THE VICTORIAN SOCIETY

16 November 2020

RE: Parkwood Methodist Church, Parkwood Road, Longwood, Huddersfield, HD3 4TT (Grade II, 1868): Listed Building Consent for alterations to convert former church to 12 residential units, formation of parking areas and widen vehicular access (within a Conservation Area).

Drawn: DRH
 Date: Aug 2018
 Scales: 1:100 @ A1
 Drawing No.: 17-023-06
 Rev: A

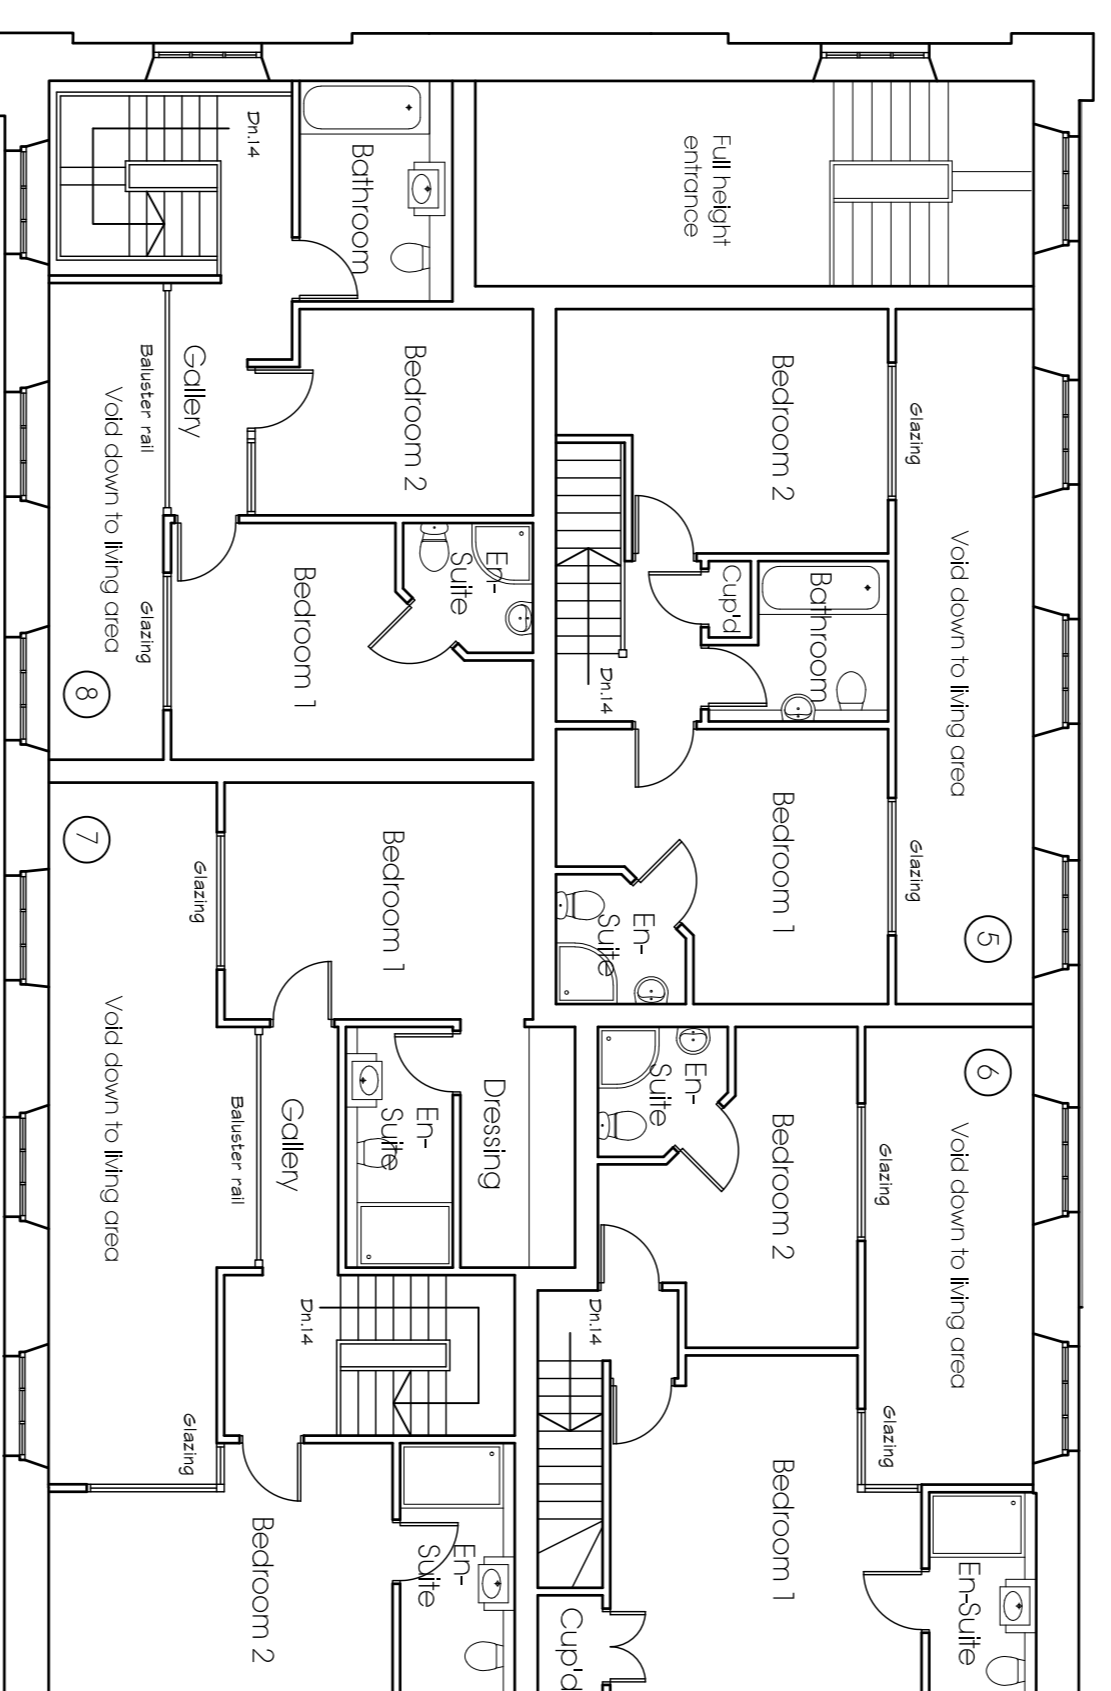
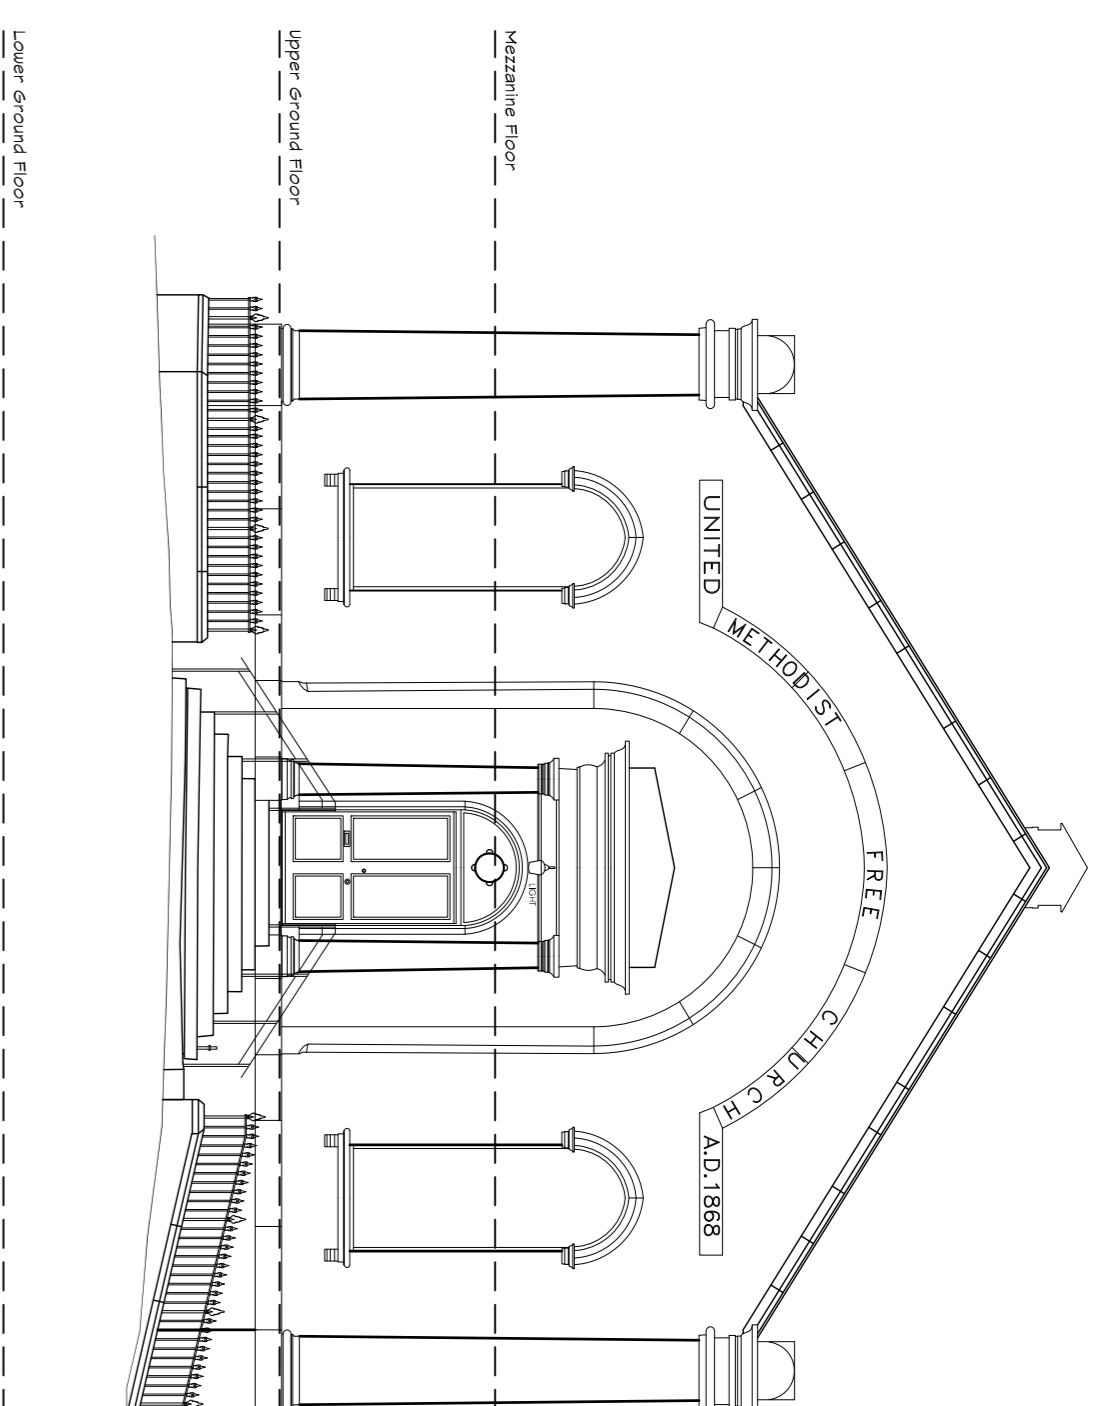
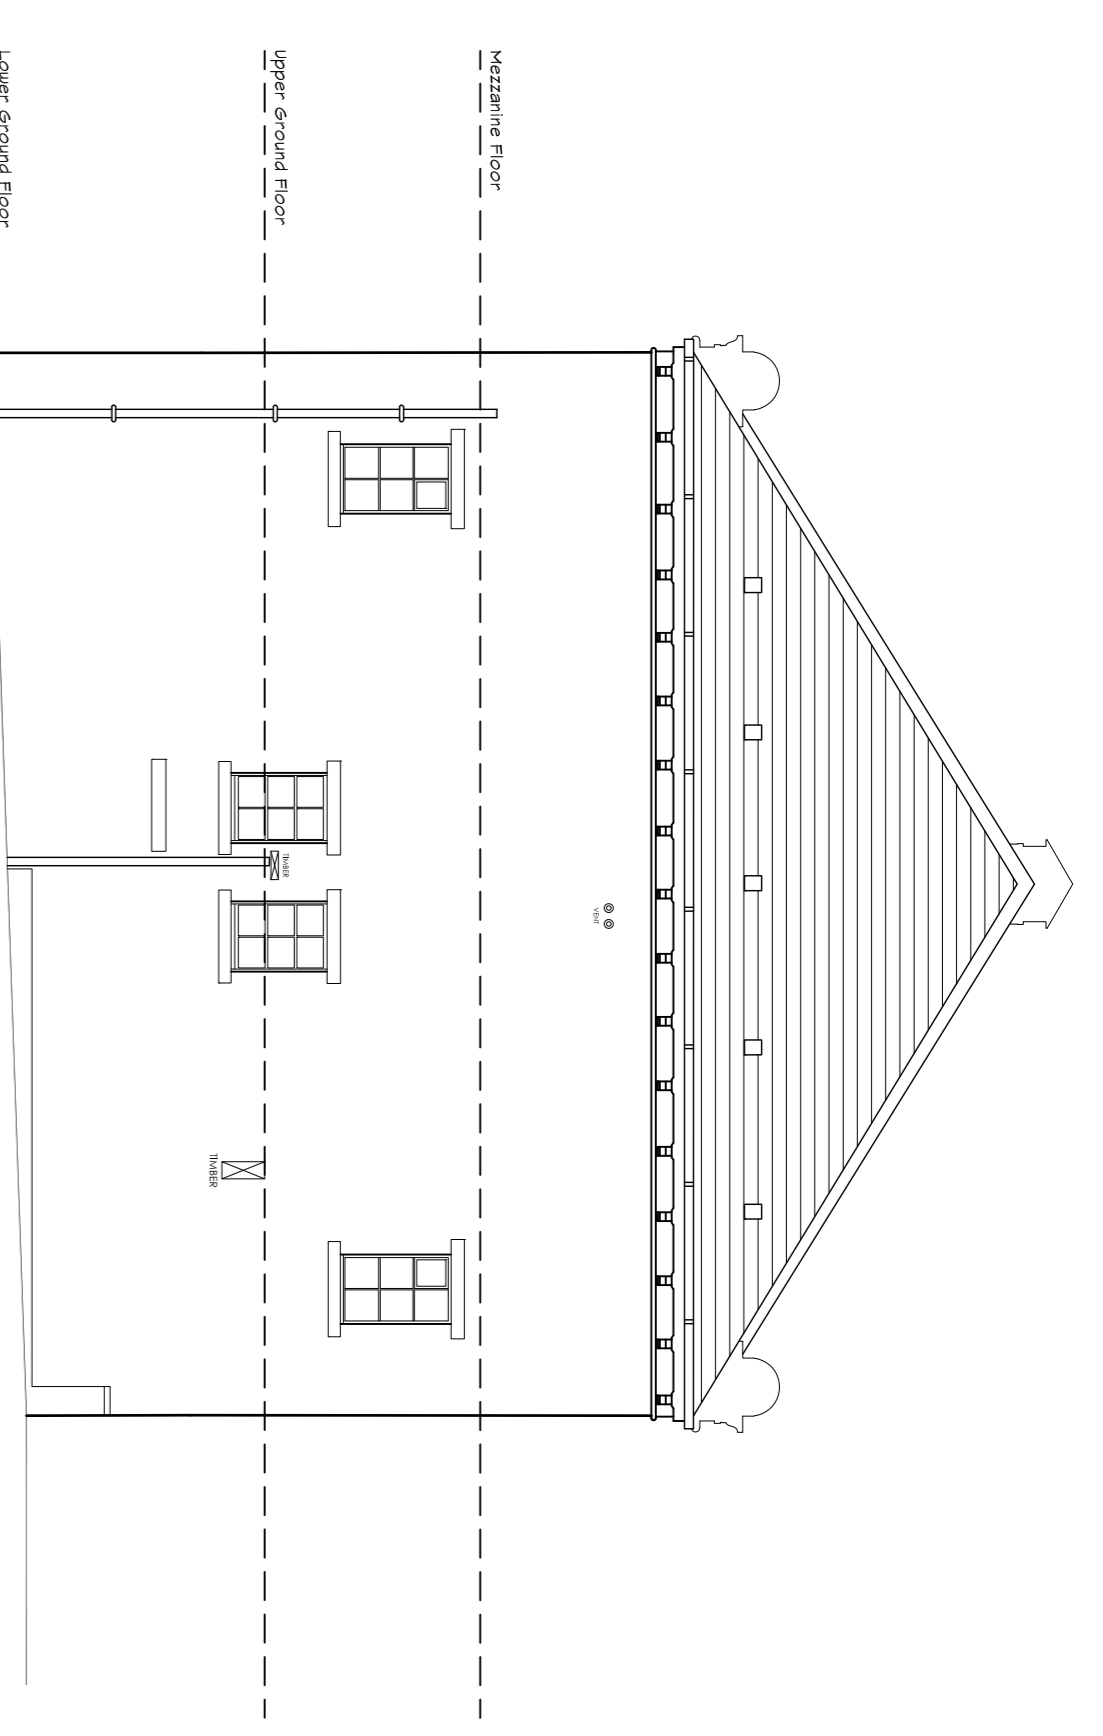
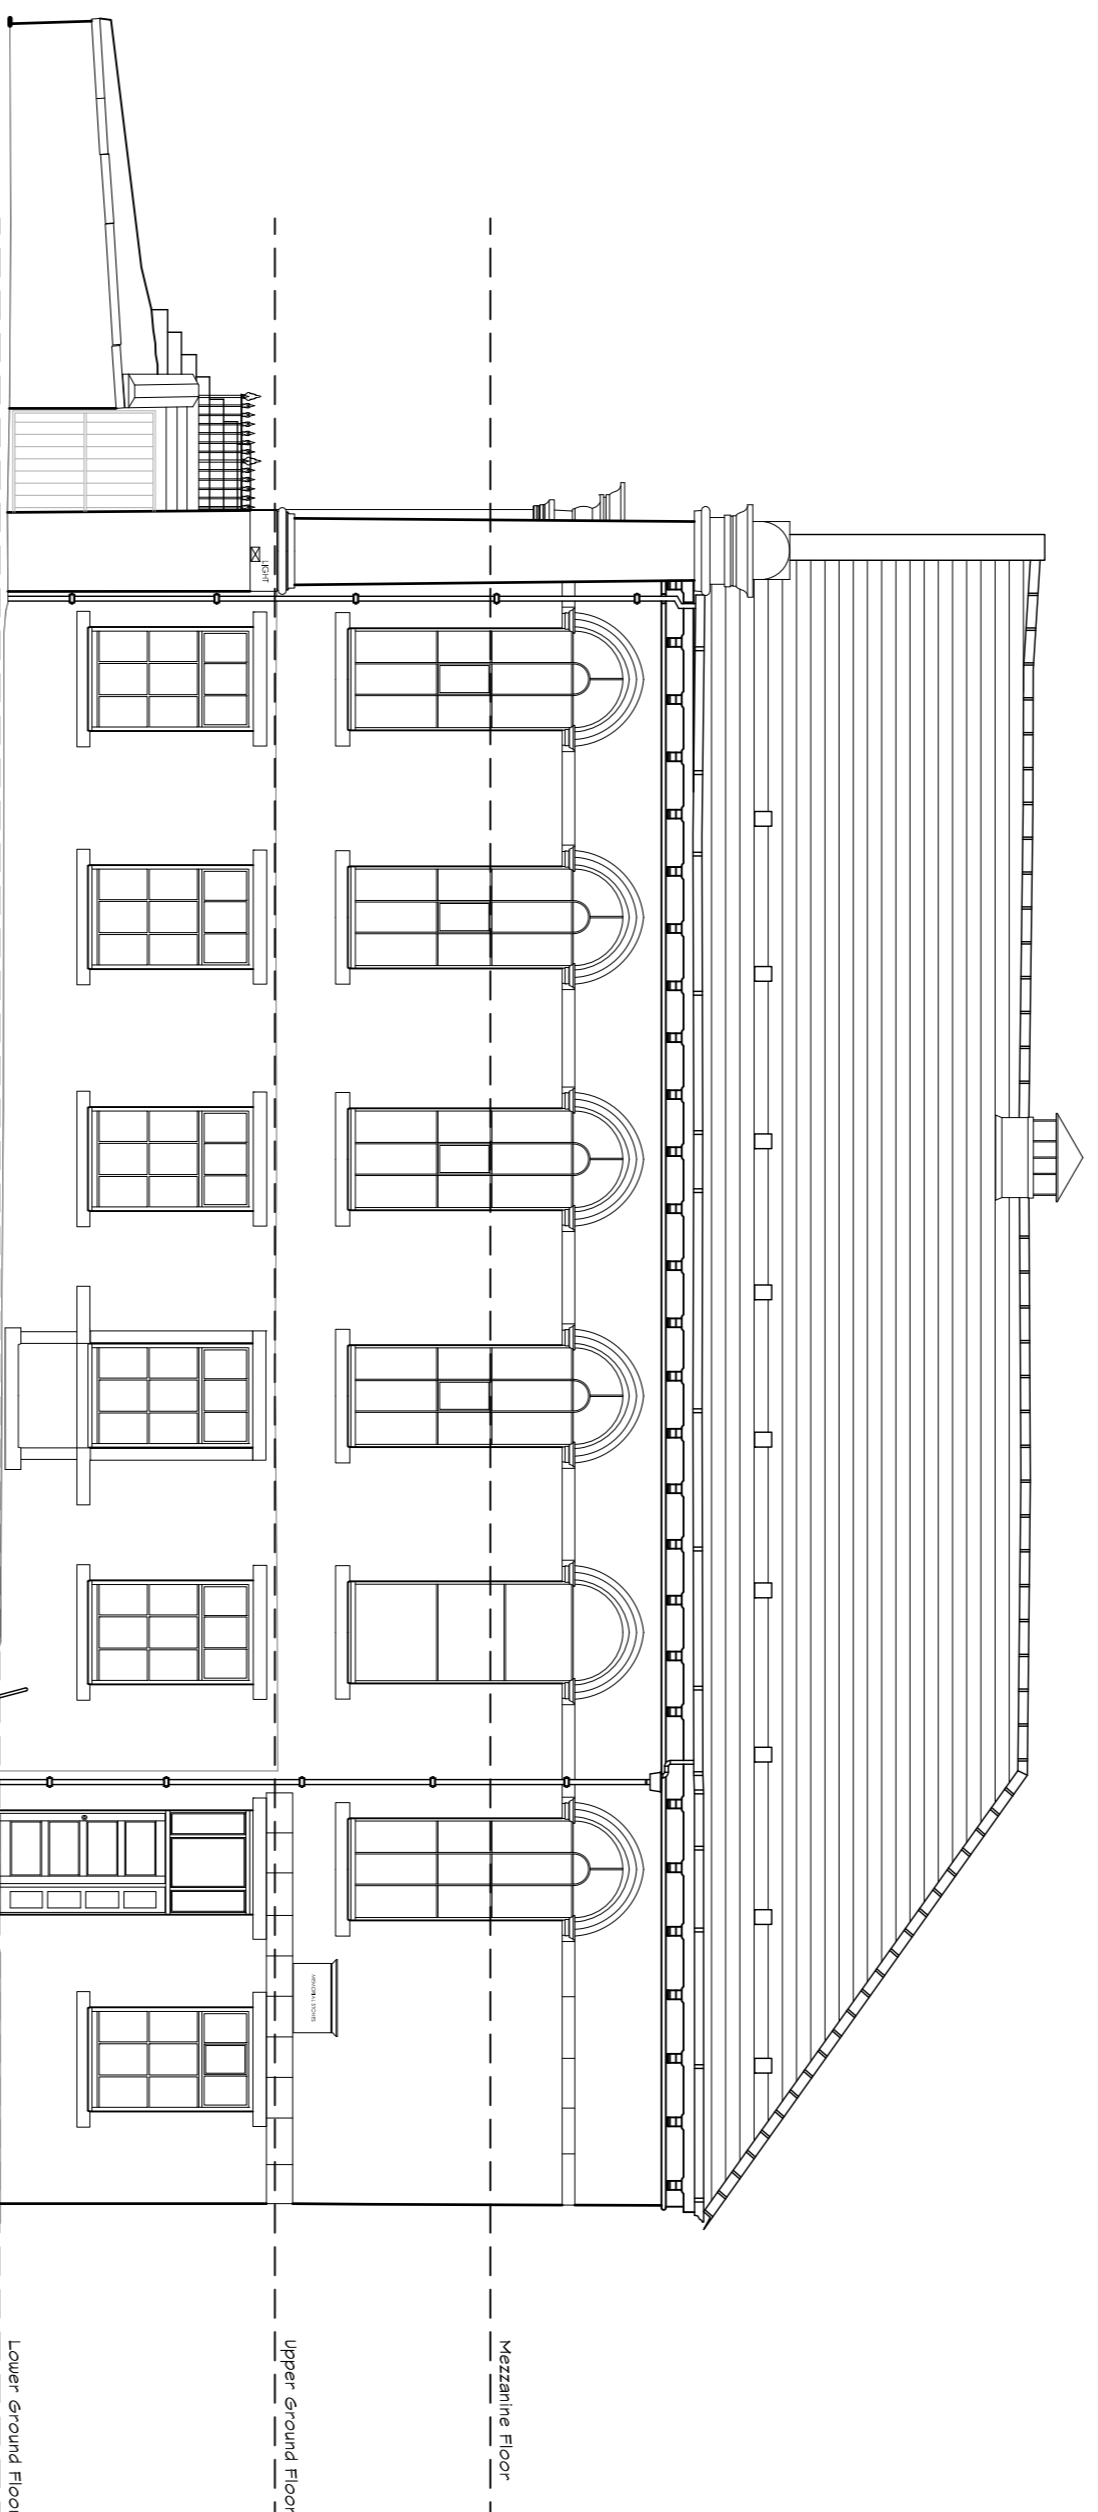
In our previous objection (25 March 2020, attached for reference) we wrote that the total loss of the intact historic interior would result in **substantial harm** to the significance of the building. Although the plans have been altered so that the inserted mezzanine no longer cuts across the double-height windows, the proposals still involve the total loss of the historic interior, and remain a clear example of substantial harm to a designated heritage asset. Apart from the revised plans and elevations no further information has been provided to meet the requirements of the NPPF, in particular paragraphs 189 and 195. We must therefore reiterate our strong objection to this extremely harmful scheme, and once more urge your authority to refuse consent, as required by national policy.
